RESPONSE TO SUBMISSIONS DESIGN REPORT

1 BARRACK LANE, 81-83 GEORGE ST, PARRAMATTA

25013

RESPONSE TO SUBMISSIONS

GROUND FLOOR CONNECTION TO THE STABLES

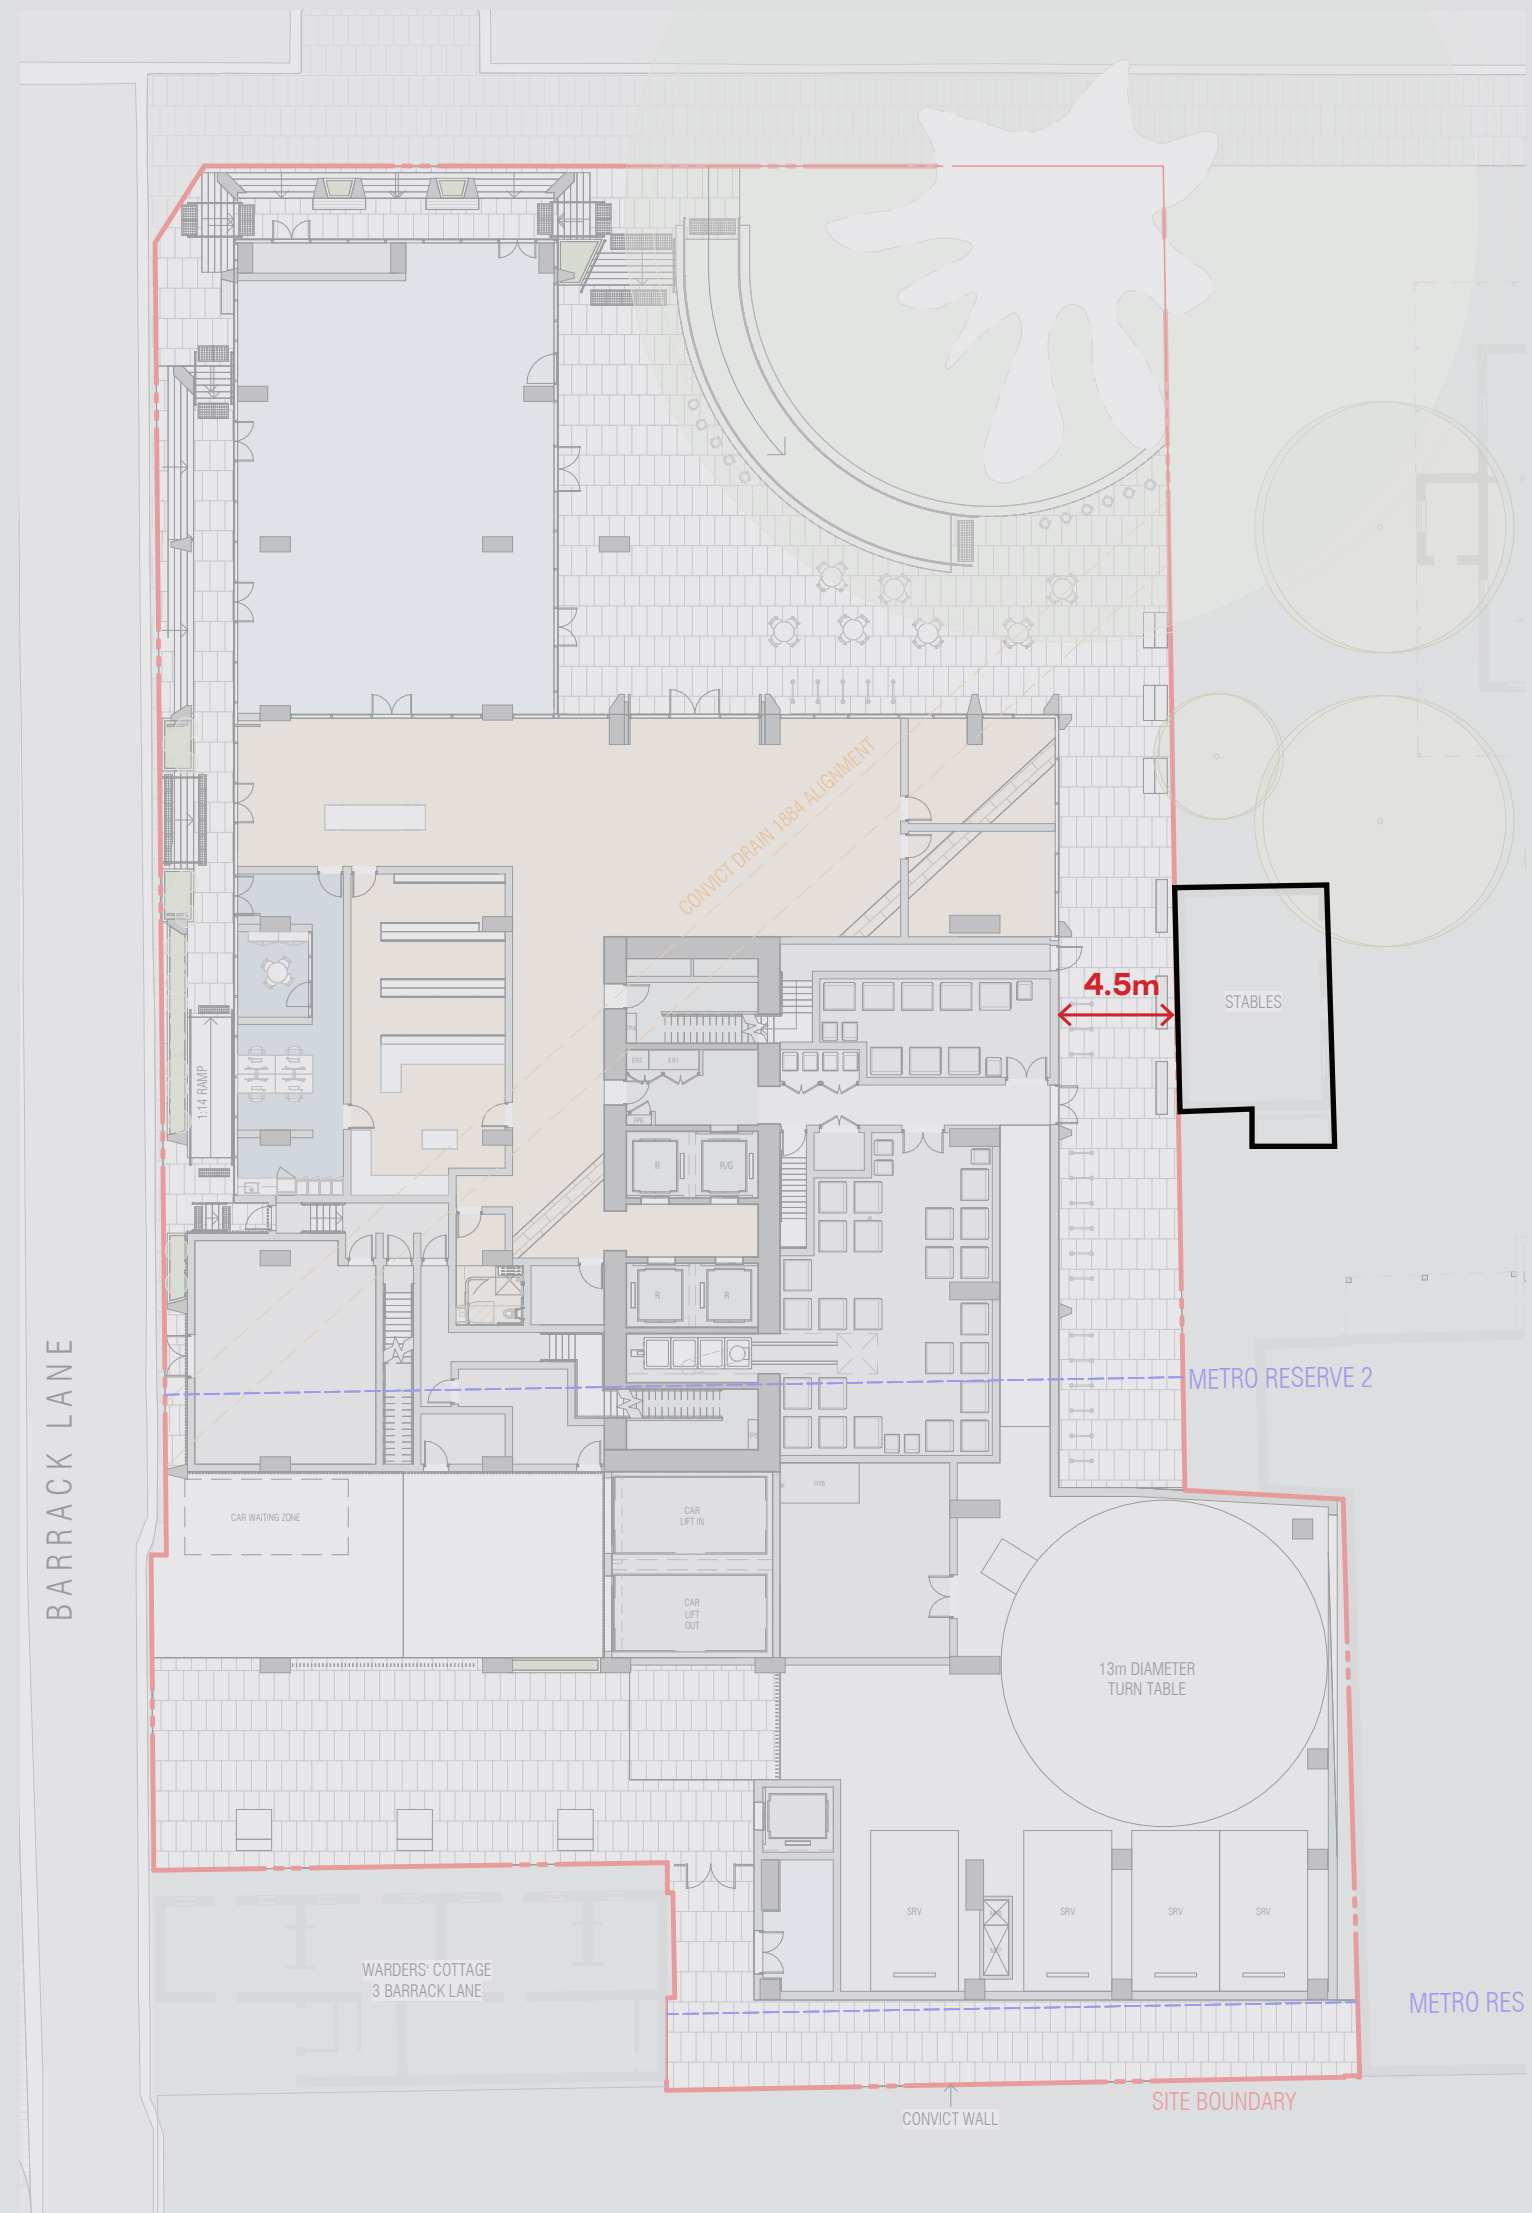
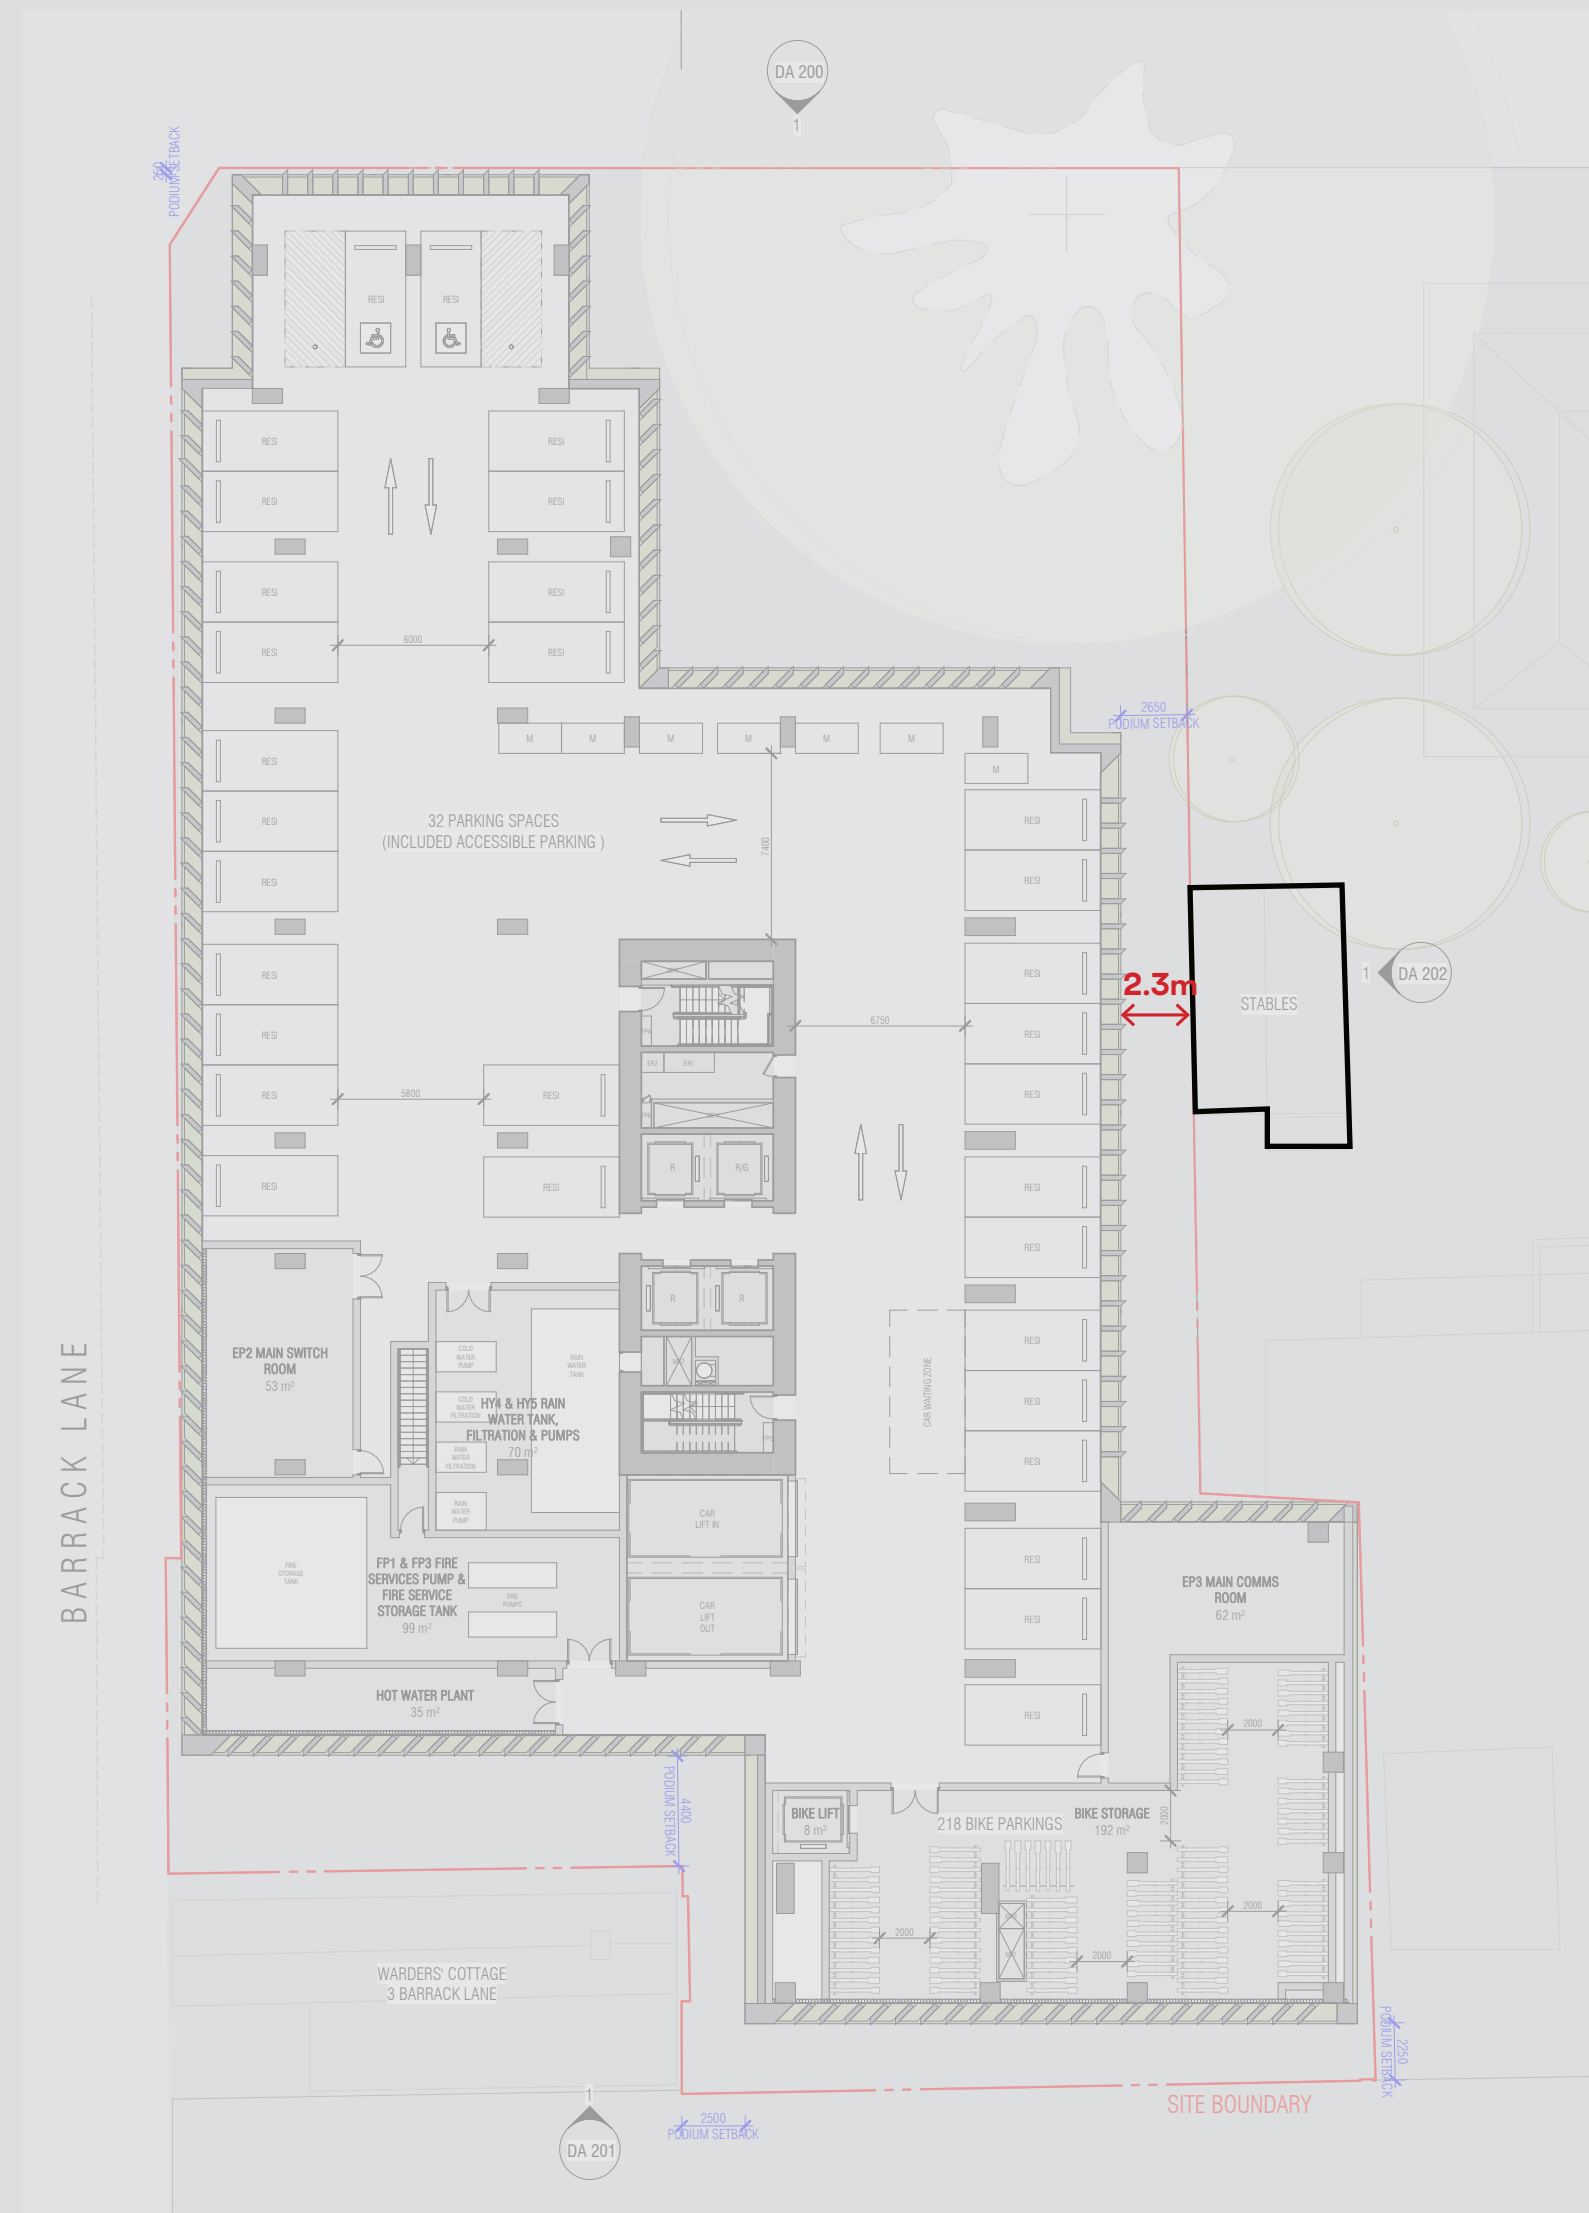
DPHI-20	<ul style="list-style-type: none"> Provide consideration into the visual impact to the Perth House and The Stables from the reducing the setback to the upper podium 	<p>The podium and tower setbacks have been reviewed to ensure appropriate visual separation from Perth House and The Stables. The design has been refined in consultation with Heritage NSW to strengthen the interface with The Stables and enhance the heritage setting. The articulated podium form, calibrated scale and considered material palette work to reduce perceived bulk, providing a recessive and respectful backdrop to these significant heritage items. The incorporation of façade planting further softens the built form.</p> <p>Refer to detailed description provided in Section 2.6</p>

ITEM	KEY ISSUES	RESPONSE
HNSW-6	<ul style="list-style-type: none"> Although there is a 4,500mm setback between the podium and the Perth House stables building at ground floor level, this setback is reduced to just 2,650mm for the upper levels of the podium. Please advise on why this setback cannot be increased to allow a wider visual buffer zone around the stables building. 	<p>In consultation with Heritage NSW, the interface with The Stables has been refined to improve its relationship to the heritage item. The façade column line has been set back to align with the glazing, increasing separation and reducing the visual prominence of the structure at ground level.</p> <p>Refer to Section 2.6 of this report.</p> <p>Refer to Heritage response prepared by Urbis and RTS Report prepared by Mecone.</p>

REV. **B** DRAWING NO. **DA* 100A**

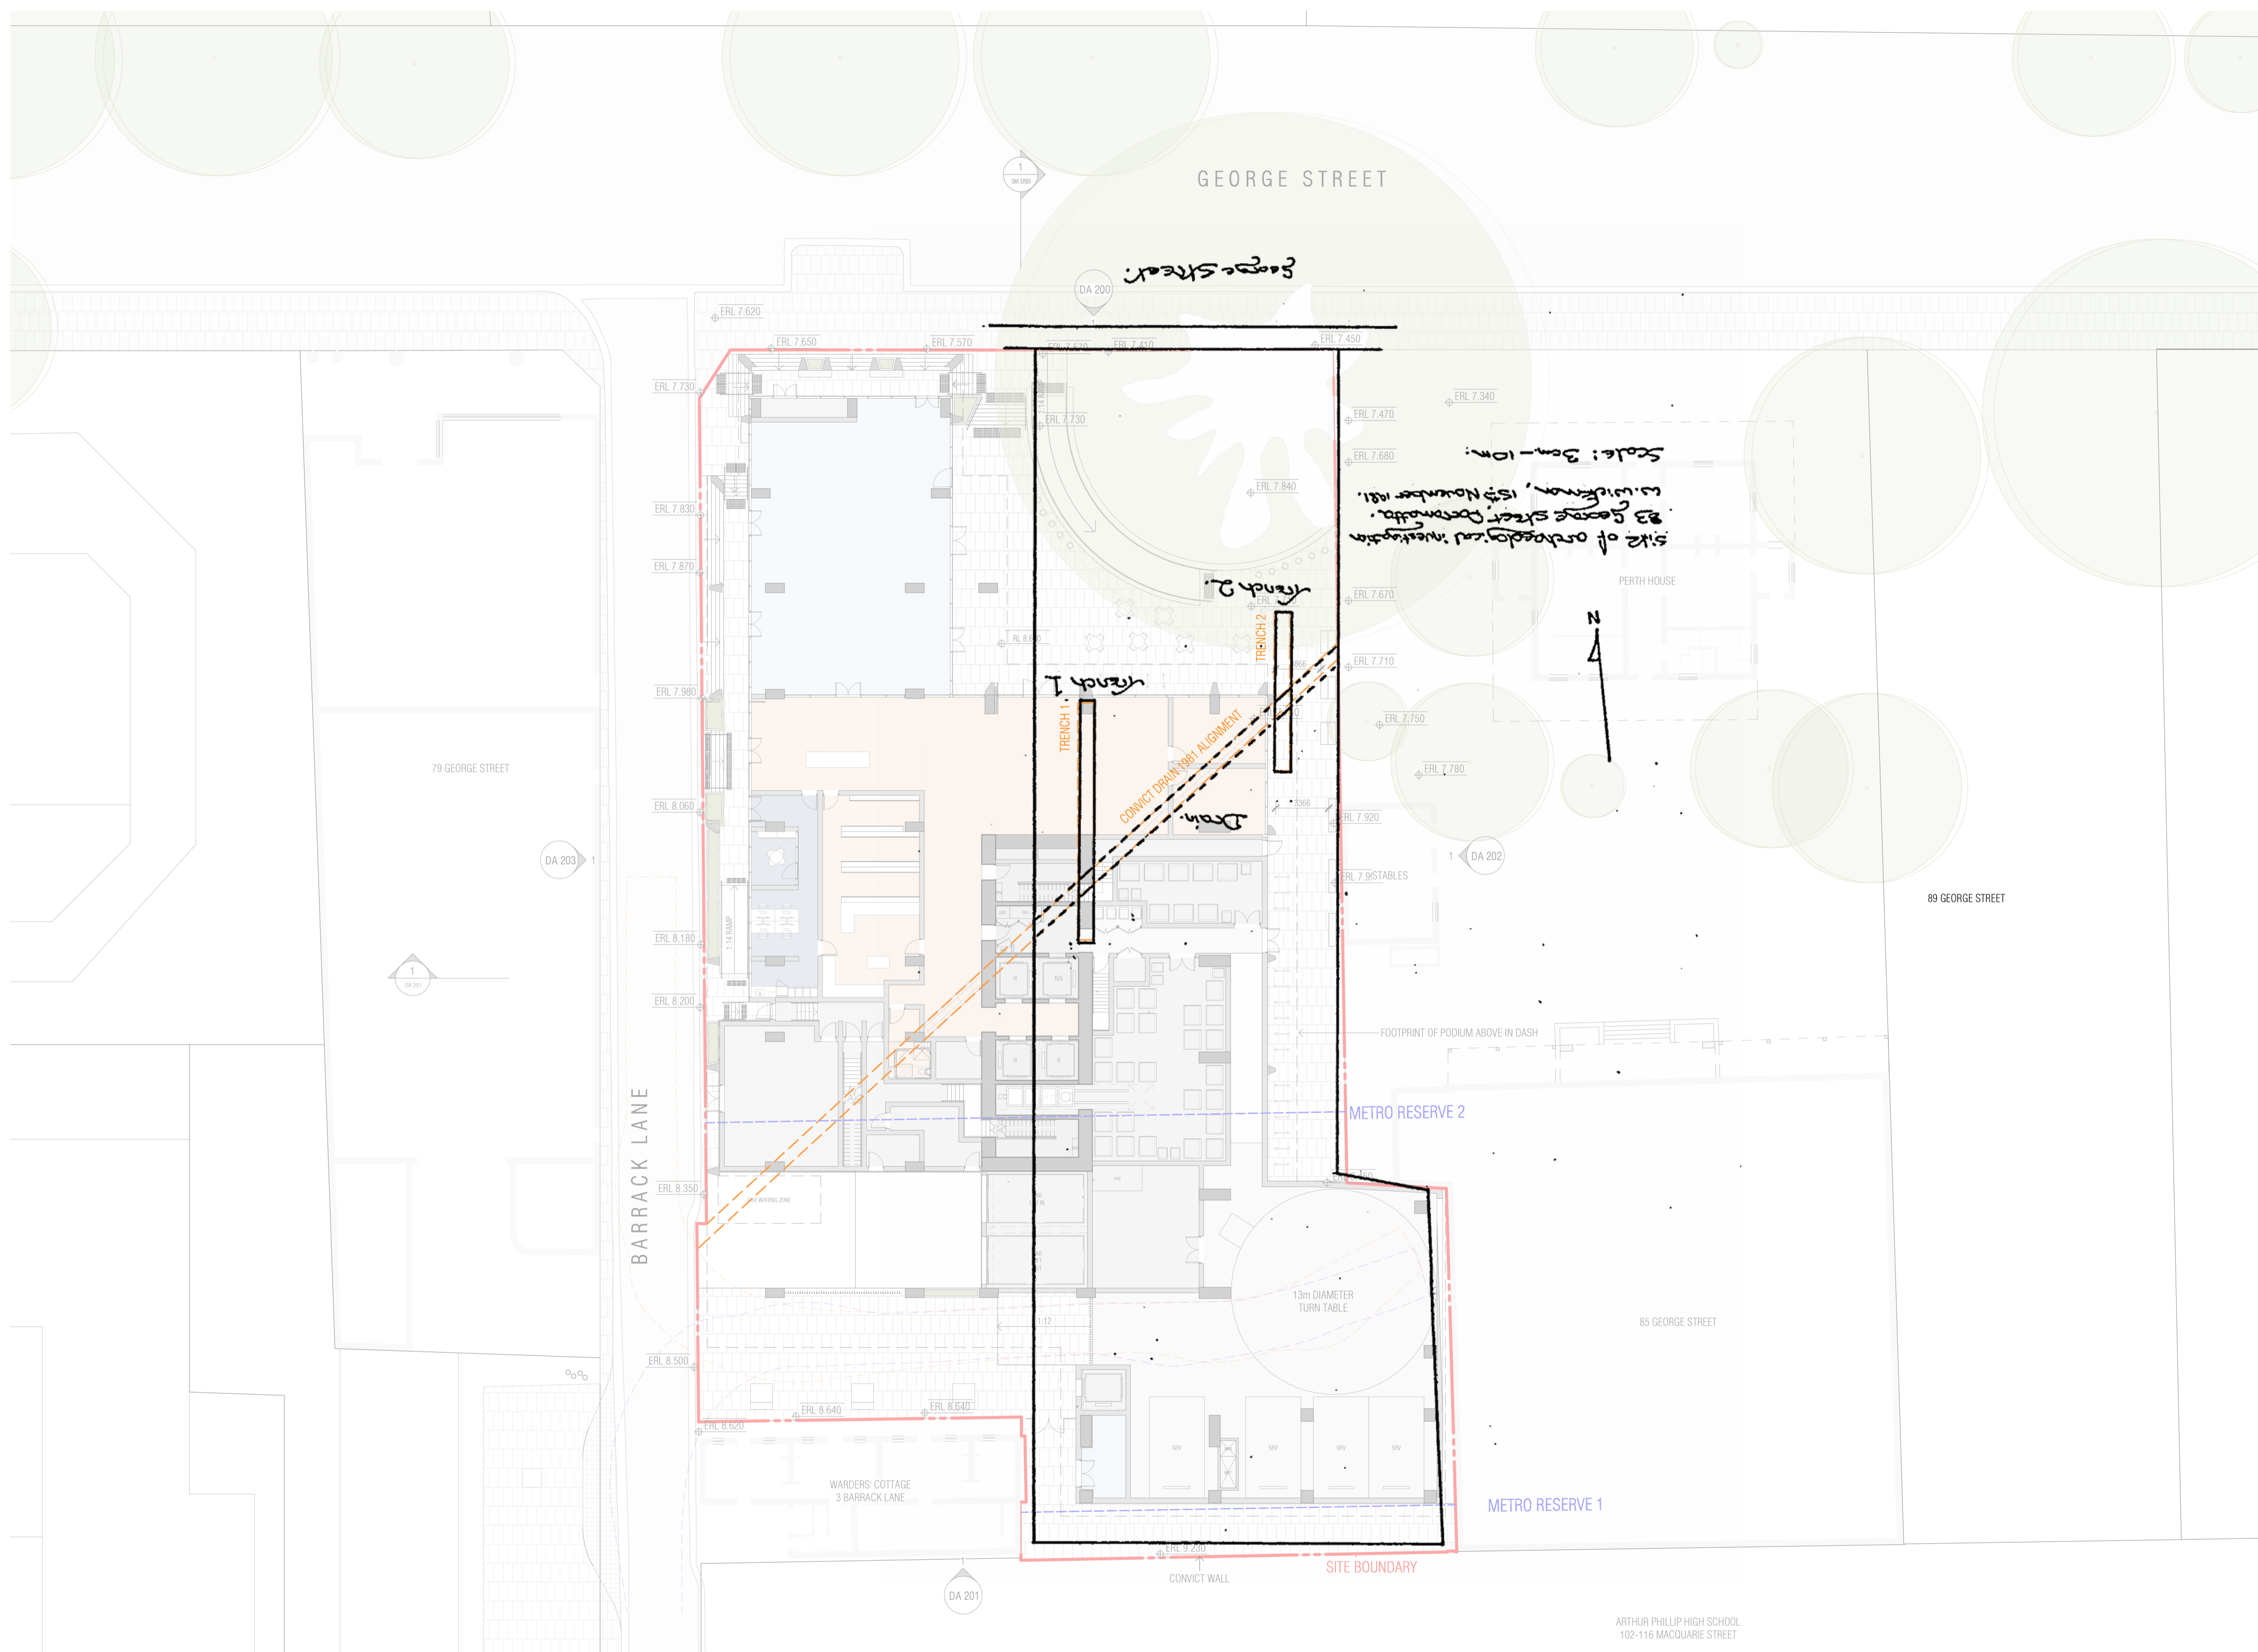
COP-35	<ul style="list-style-type: none"> The location of the car waiting area on the parking levels will likely obstruct the swept paths of vehicles exiting the lift. Accordingly, a swept path assessment should be undertaken and the car waiting areas to be revised accordingly. 	<p>A swept path assessment has been undertaken by JMT confirming adequate vehicle manoeuvrability. The car waiting bay has been relocated to achieve clearance.</p> <p>Refer to Section 2.9 of this report.</p>
